CITY OF PORTLAND, MAINE
DEVELOPMENT REVIEW APPLICATION
PLANNING DEPARTMENT PROCESSING FORM
DRC Copy

Ruby Lane #14

November 9, 2005

RE: Application for Single Family Residences, Ruby Lane lots #13 and lot #14

LOT 14 LAYOUT & UTILITIES PLAN

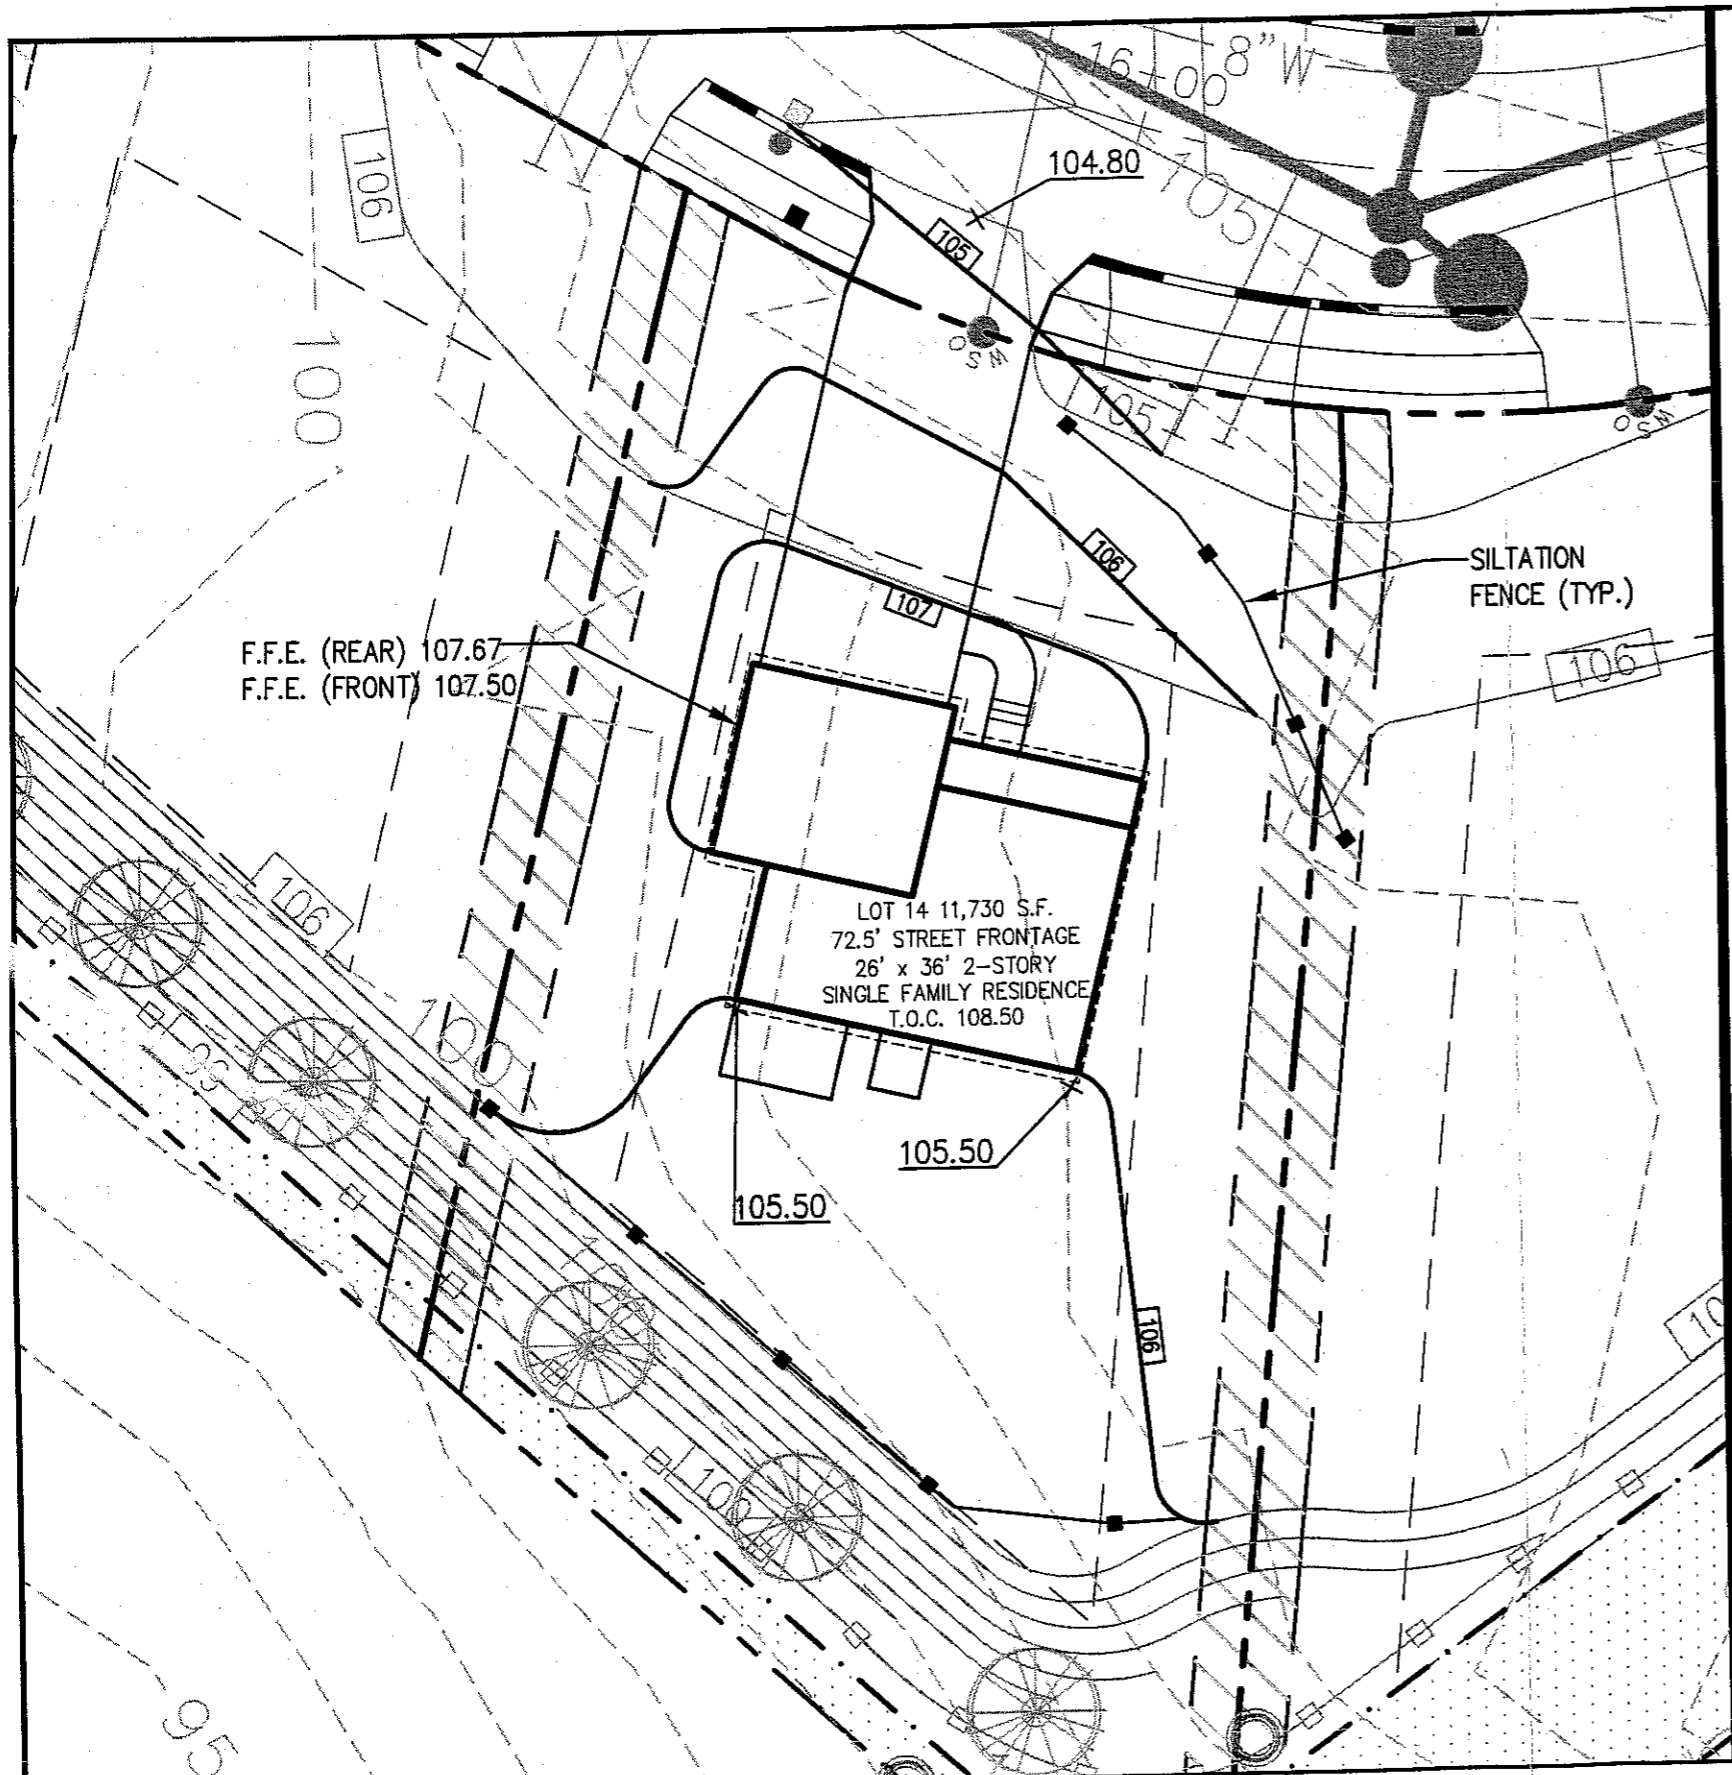
1. Please add two street trees to your plan.
2. Same items listed above (2., 3., and 4.).
